**WYKHAM PARK FARM,
A361 BLOXHAM ROAD, BANBURY**

**PROPOSED RESIDENTIAL DEVELOPMENT
SECTION 38 WORKS**

Stage 1 Road Safety Audit

DL-EB-21-3344-RSA1

TITLE <b>SPINE ROAD GENERAL ARRANGEMENT SHEET 2 OF 5</b>	
HYDROCK PROJECT NO. <b>C-04841-C</b>	SCALE @ A1 <b>1:500</b>
STATUS DESCRIPTION <b>PLANNING</b>	STATUS <b>S2</b>
DRAWING NO. (PROJECT CODE-ORIGINATOR-ZONE-LEVEL-TYPE-ROLE-NUMBER) <b>WPF-HYD-XX-XX-DR-C-0006</b>	REVISION <b>P12</b>

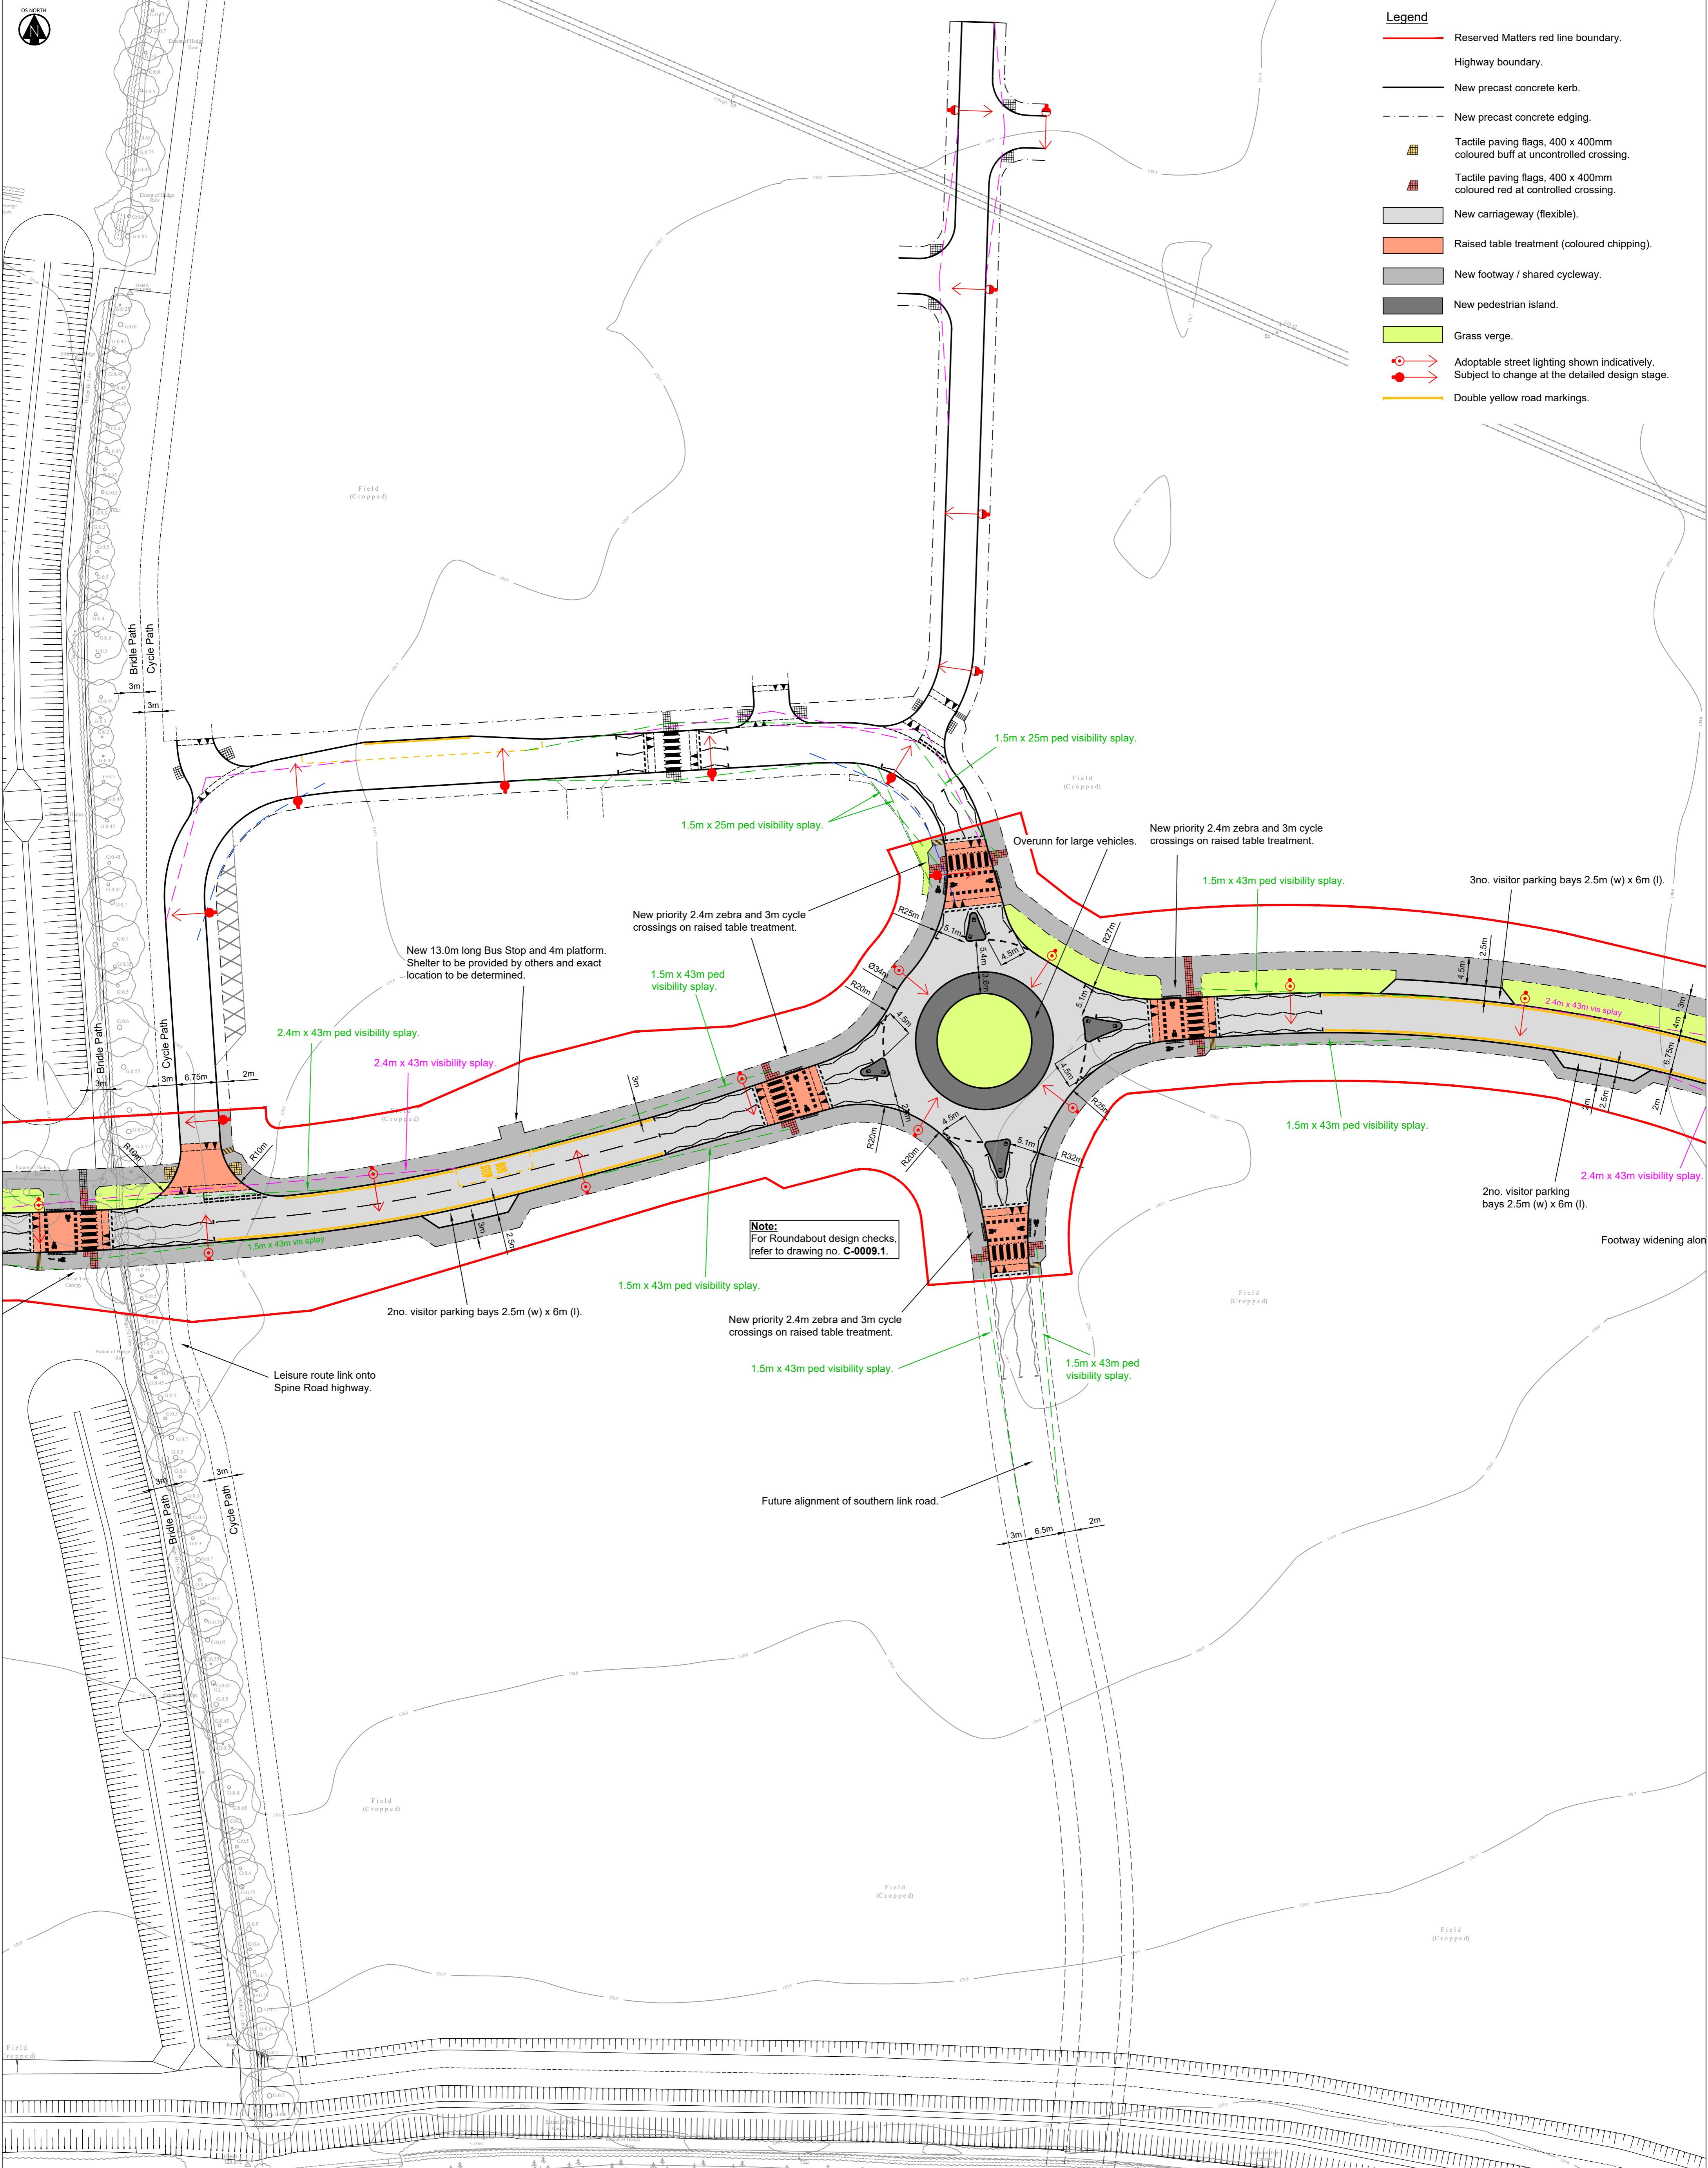
The Audit Team noted that a bus stop is located very close to the A361 roundabout when entering the development spine road. Drivers entering the spine road may be tempted to overtake buses waiting at the stop and this increases the risk of head on collisions with vehicles turning right out of the first side road on the northern side of the spine road.

The Audit Team noted that the stem of the “L” shaped tactile paving on the northern side of the spine road adjacent to the ancillary road “T” junction and on the eastern arm of the internal development roundabout does not extend to the back edge of the footway.

The stem of the ‘L’ shaped tactile paving is positioned on the left hand side on the northern and eastern arm crossing point of the internal development roundabout.

The black and white stripes at the parallel crossing on the southern arm crossing point of the internal development roundabout are missing.

The Audit Team noted that the bus stop falls within the pedestrian visibility splay to the parallel crossing on the eastbound approach to the internal development roundabout. This reduces visibility for drivers overtaking a stationary bus on the approach to the parallel crossing and increases the risk of them colliding with a pedestrian crossing from north to south on the parallel crossing.

It is recommended that a bus stop layby is provided at this location.

It is recommended that the stem of the “L” shaped tactile paving extends to the back edge of the footway and should be on the right hand side of the crossing point.

The tactile paving across the cycle crossing point should be removed in accordance with TSM Chapter 6. It may be appropriate to install road markings to diag. 1057 to highlight the cycle side of the crossing.

The black/white stripes associated with the zebra part of the parallel crossing should be installed.

It is recommended that the bus stop is relocated to a position outside the pedestrian visibility splay at the parallel crossing.

TITLE <b>SPINE ROAD GENERAL ARRANGEMENT SHEET 5 OF 5</b>	
HYDROCK PROJECT NO. <b>C-04841-C</b>	SCALE @ A1 <b>1:500</b>
STATUS DESCRIPTION <b>PLANNING</b>	STATUS <b>S2</b>
DRAWING NO. (PROJECT CODE-ORIGINATOR-ZONE-LEVEL-TYPE-ROLE-NUMBER) <b>WPF-HYD-XX-XX-DR-C-0009</b>	REVISION <b>P10</b>

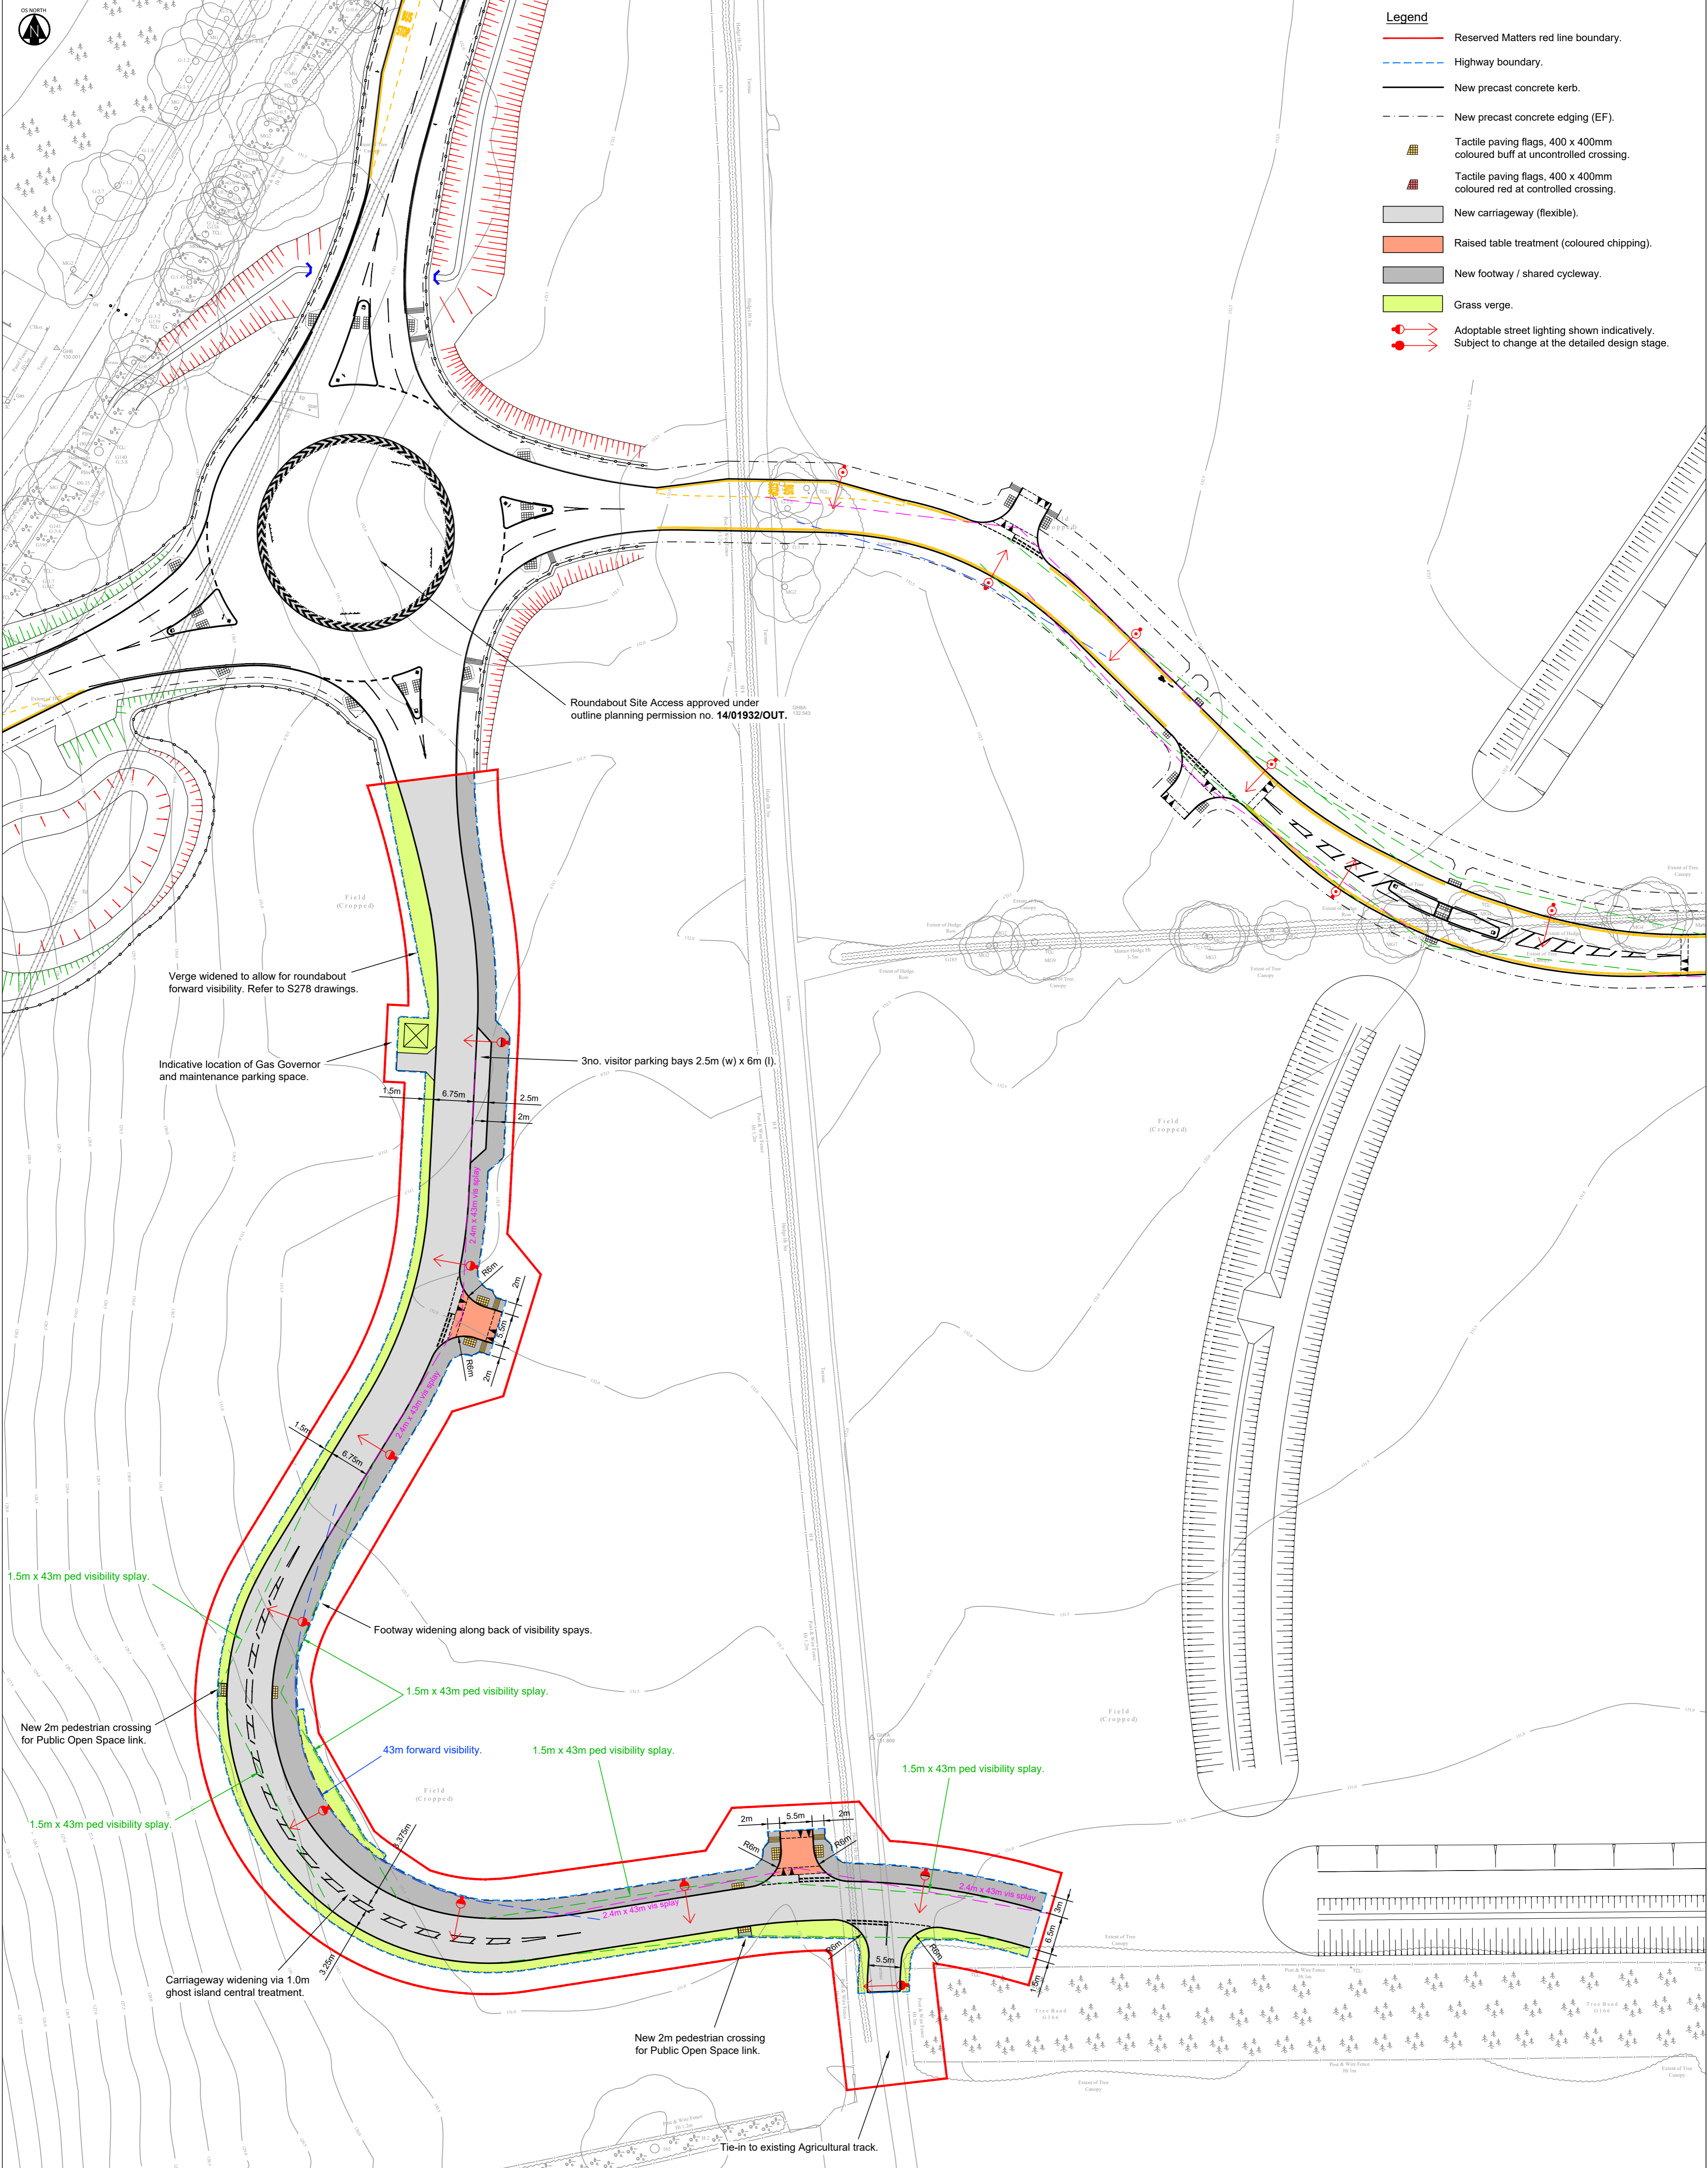
There appears to be a missing link between the shared route on the southern side of the Spine Road east of the parallel crossing and the leisure route and between the leisure route and shared route on the northern side of the Spine Road at the eastern end of the development. This may lead to cyclists continuing on the footway leading to collisions with pedestrians resulting in user injury.

It is recommended that the shared route is extended on the southern side to link the leisure route with the shared route.

UNCONTROLLED CROSSING

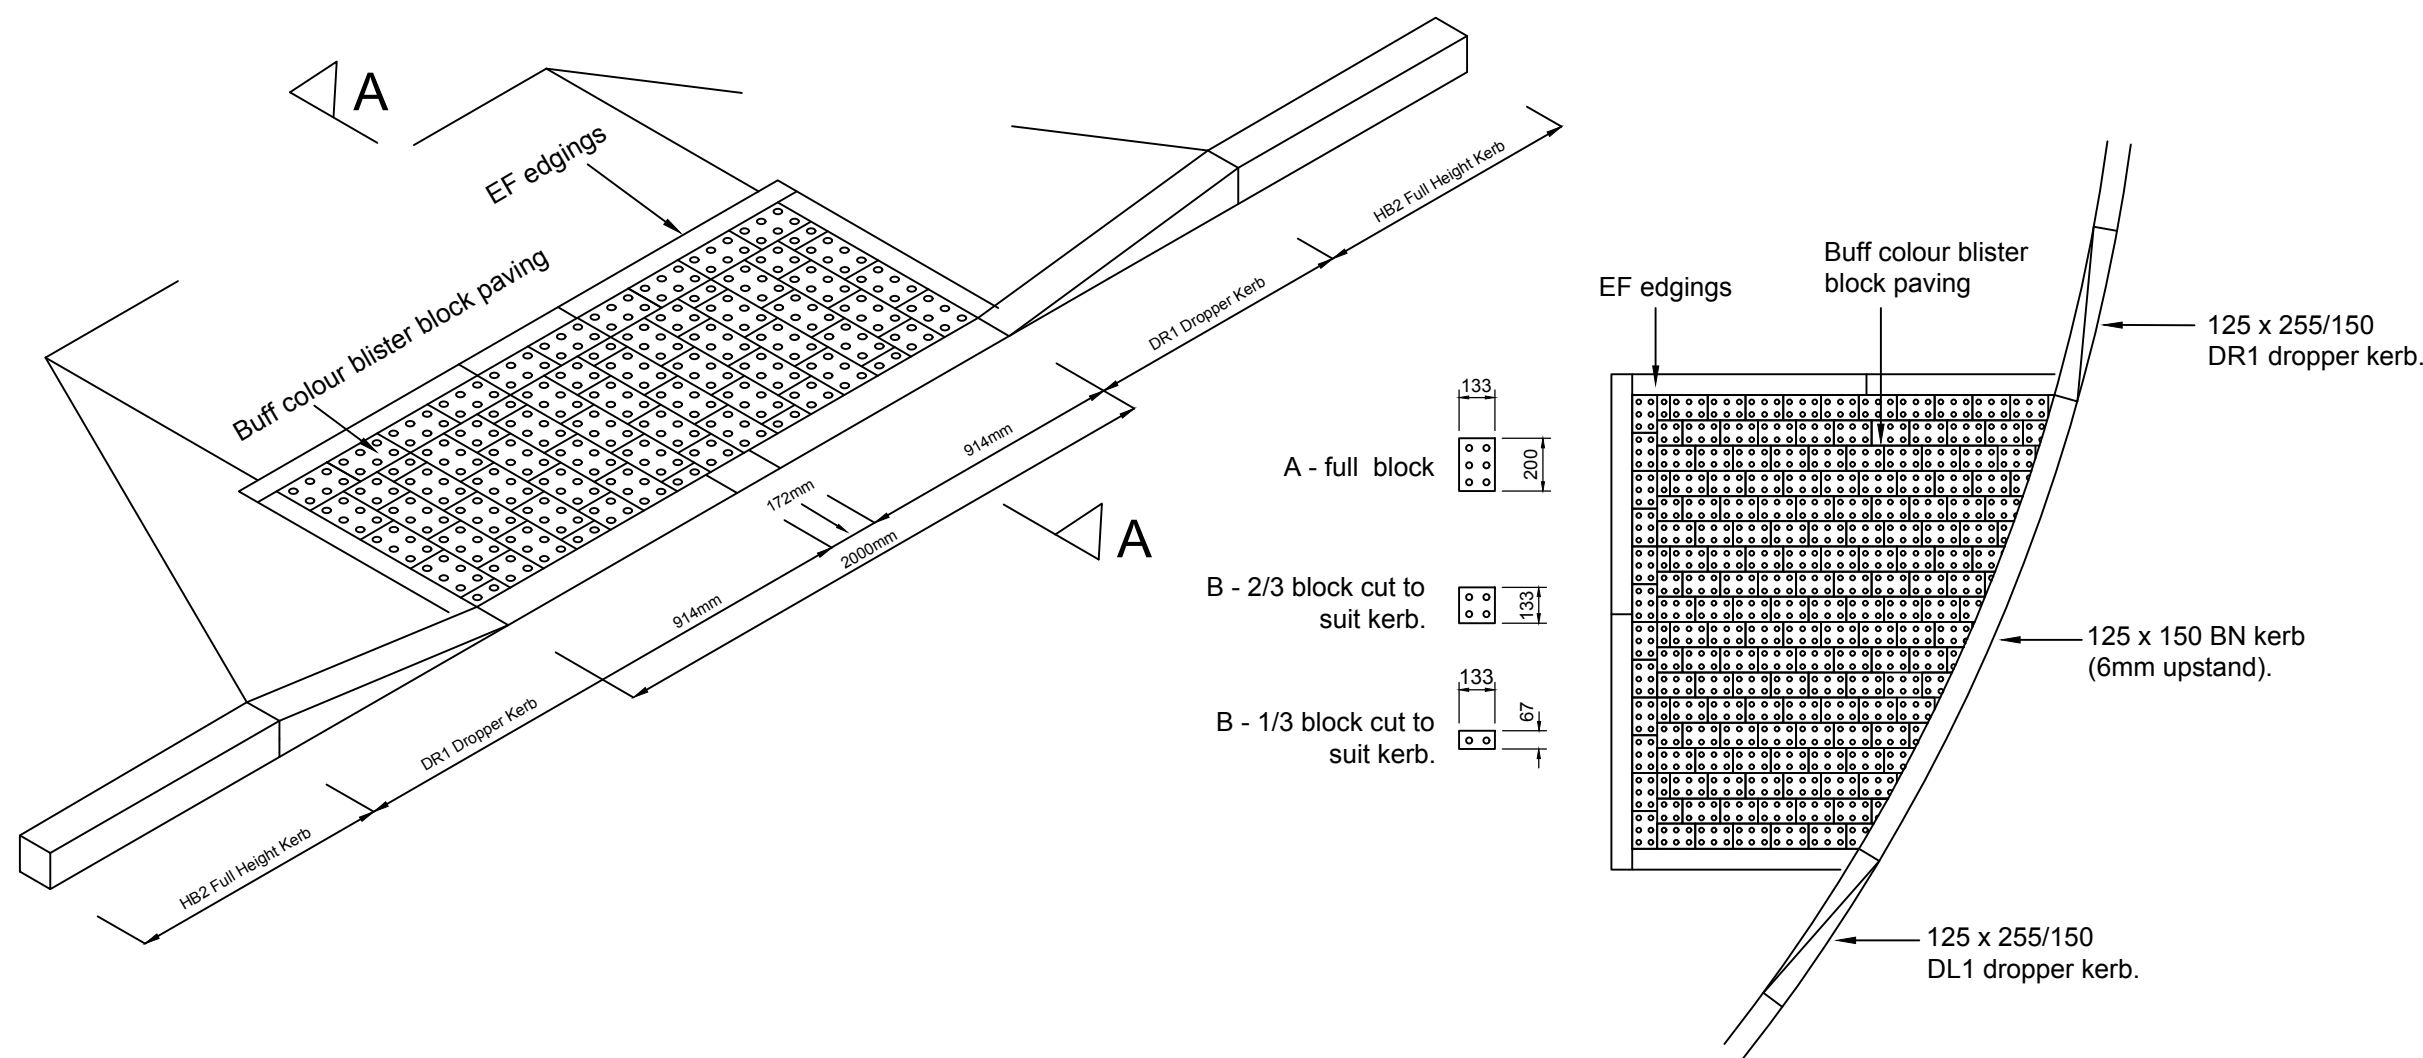
The Audit Team noted that the depth of tactile paving across a number of side road junctions on the northern side of the development side road is shown to be below the minimum recommended in current guidance for in-line uncontrolled crossings. This could result in visually impaired pedestrians entering the carriageway inadvertently and being struck by turning vehicles.

The Audit Team noted that it is proposed to use “L” shaped tactile paving to guide pedestrians to the uncontrolled pedestrian crossing points associated with pedestrian refuges on the development spine road. This could result in visually impaired pedestrians entering the carriageway believing they have priority at a controlled crossing and being struck by passing vehicles.

It is recommended that tactile paving is provided across the side roads in accordance with current guidance for in-line uncontrolled crossings.

It is recommended that tactile paving is provided in accordance with current guidance for uncontrolled crossings.
